Hillcot, 4 Home Farm Court, Main Street, Sibford
Ferris, OX15 5QT

21/01450/F

Proposal: Single storey rear extension to create open-plan kitchen, living, dining area

PROPOSED REAR ELEVATION (NORTH)
Scale 1:100 @ A1

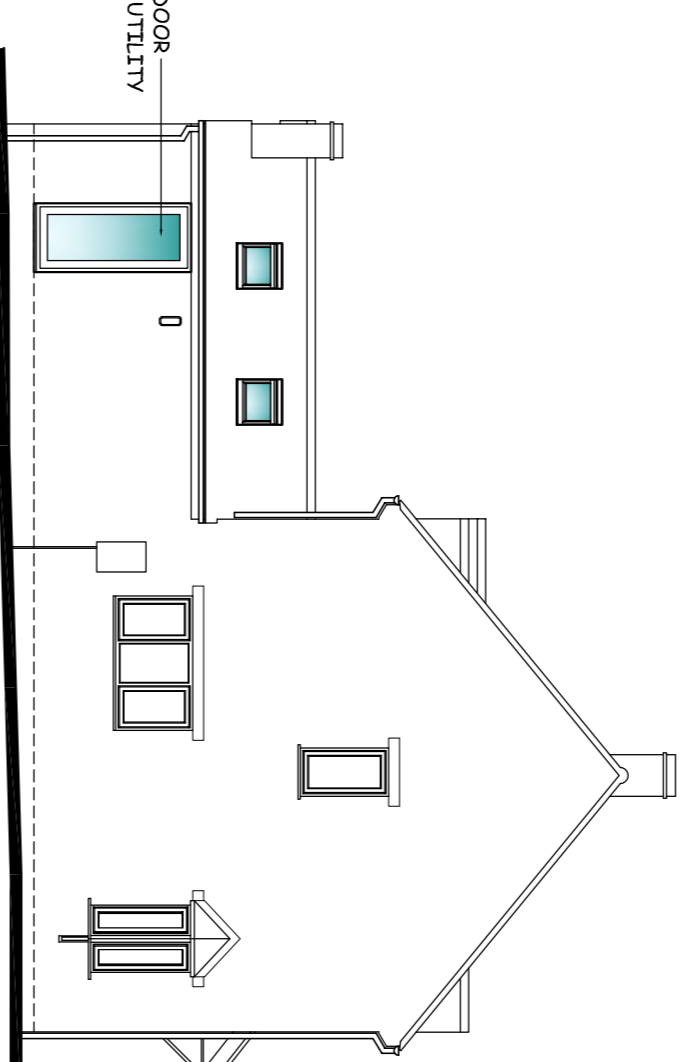
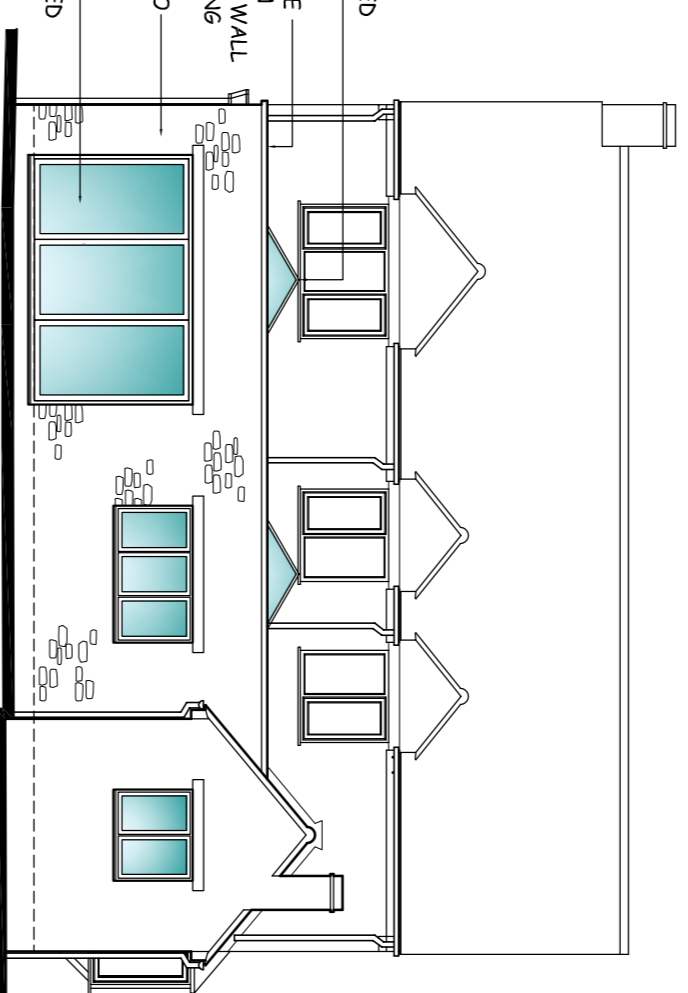
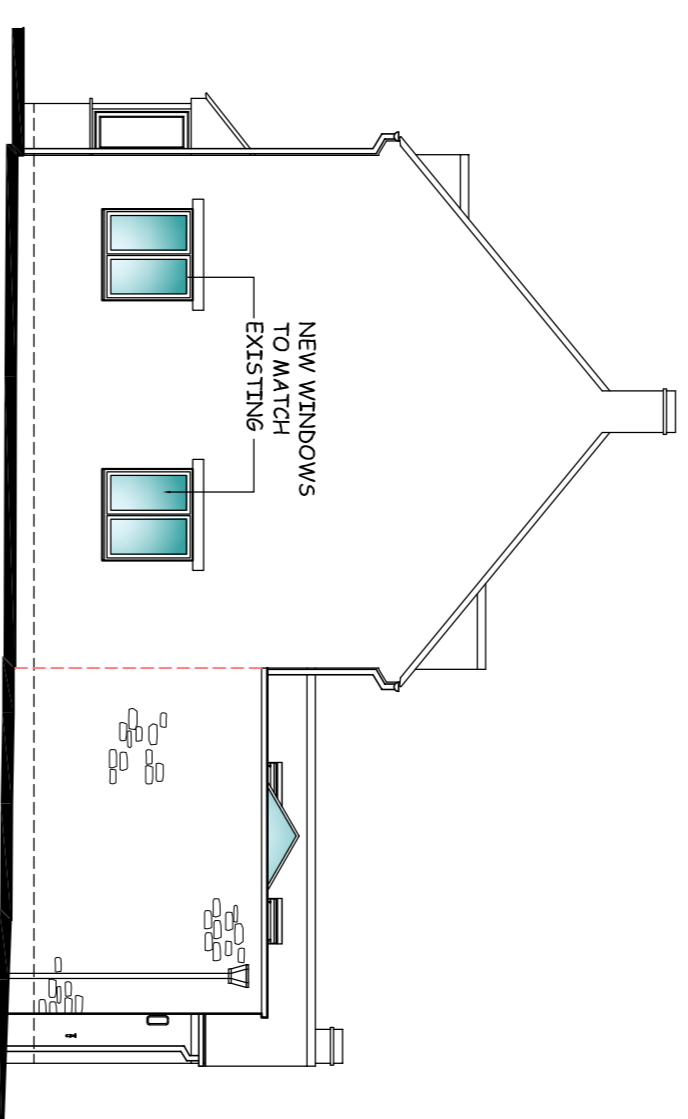
- The design would be somewhat contrived with the proposed large flat roof extension which would protrude into the side roof slope of the existing pitched rear wing. Whilst not great design, it would not be visible from outside of the application site and would not have a harmful impact on the streetscene or Conservation Area.
- The extension would be constructed from natural stone to match the existing dwelling and so the character of the site and conservation area would be retained.
- The aluminium windows and lanterns would be of high quality and would be appropriate within the conservation area.
